From: Juan Baeza
Sent: 28 June 2018 09:01
To: Planning.Responses
Subject: WA/33/18/OUT

From: [REDACTED]
Sent: 27 June 2018 09:14
To: Alison Meeus
Cc: Juan Baeza
Subject: RE: FW: Spindlewood

I am dealing with a re-consultation of planning application WA/33/18 however I am unable to respond fully as there is still information missing that I require. The applicant has now provided swept path diagrams for a refuse vehicle but I am still unsure of the visibility splays and the actual speed of the road. I asked for a speed survey and visibility splays taken to the nearside kerb. Will these be provided as I have no other comments other than the ones I made previously asking for these things.

Drawing No.
DPA 13

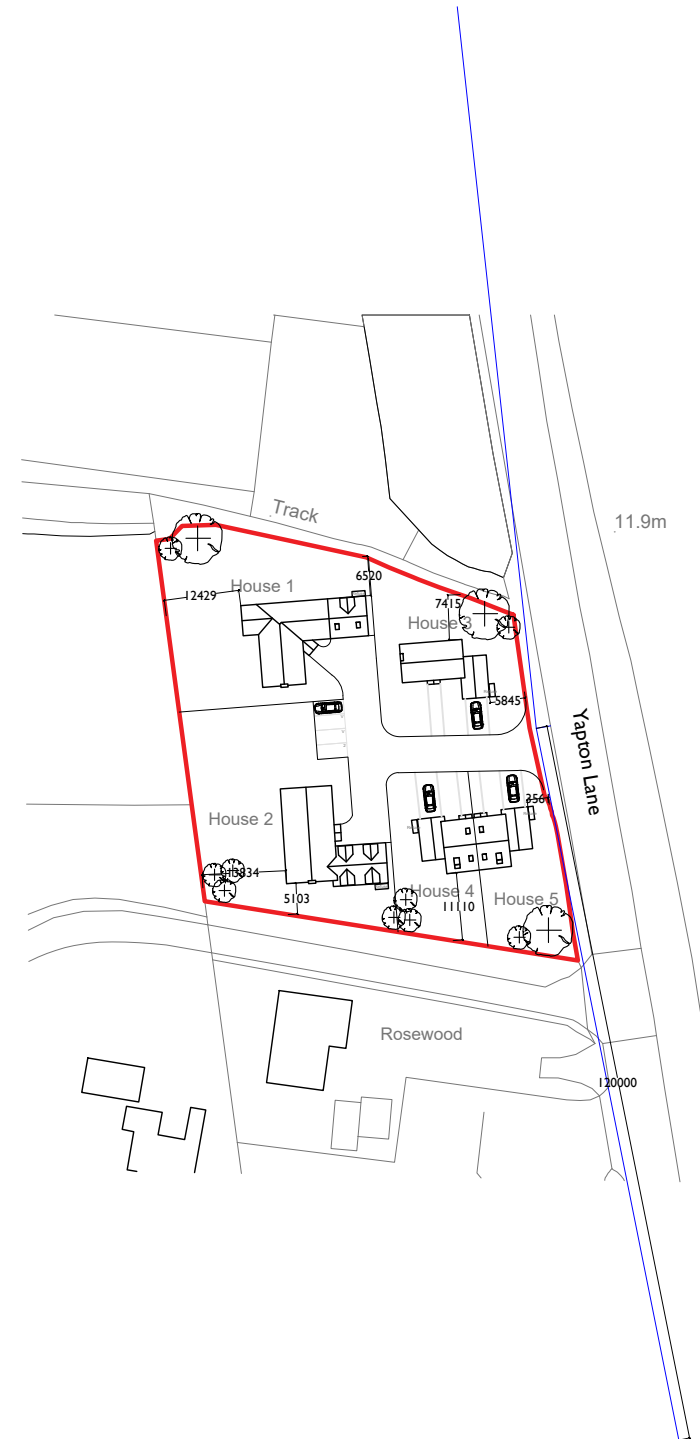
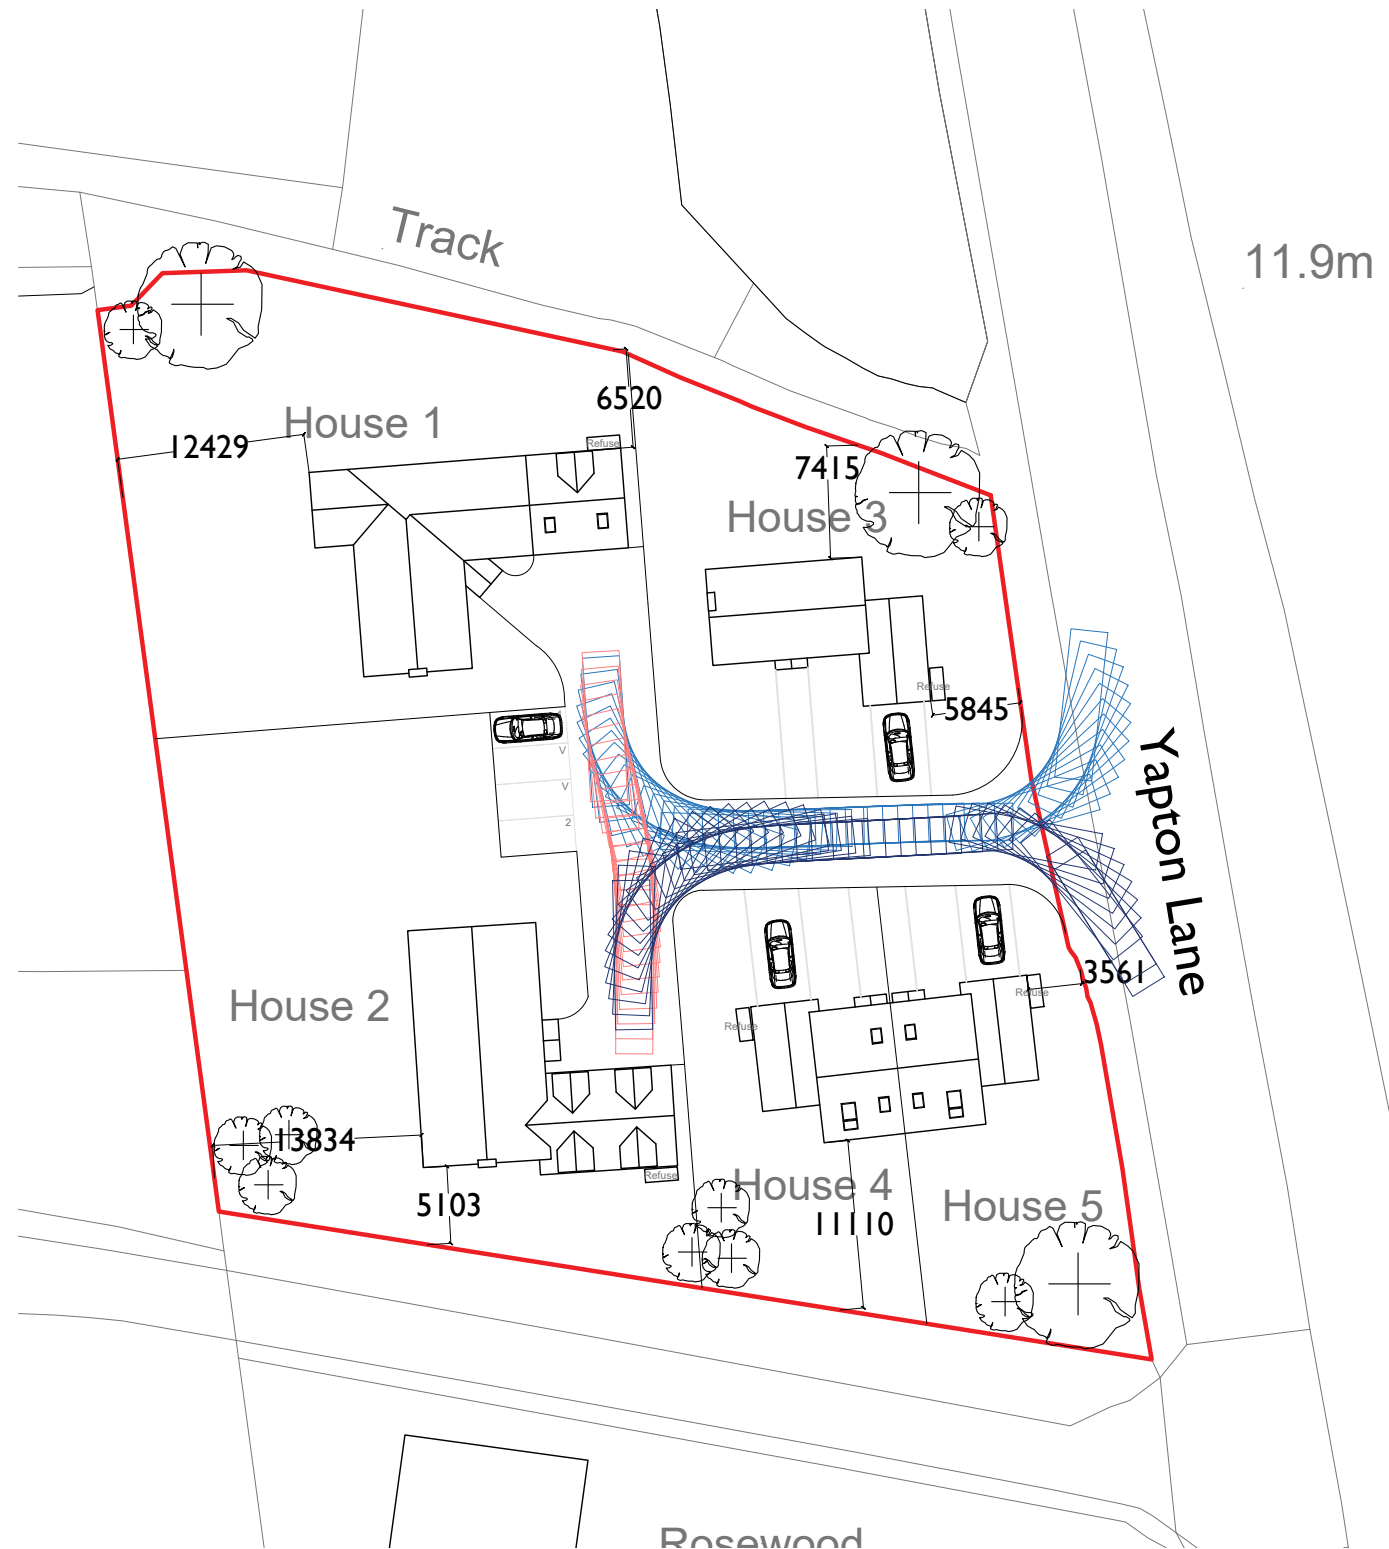
I can see a blue line on the plan but it doesn't have any annotation on it to say its 120m. Furthermore is this set back 2.4m or 2m? This should be shown as otherwise its open to interpretation.

If the 120m visibility can be provided in both directions then this will be acceptable for a 40mph road if set back 2.4m and no speed survey will be required.

Please find attached DPA 13 – Visibility Splay. This is show with dimensions of 2.4m and 120m.
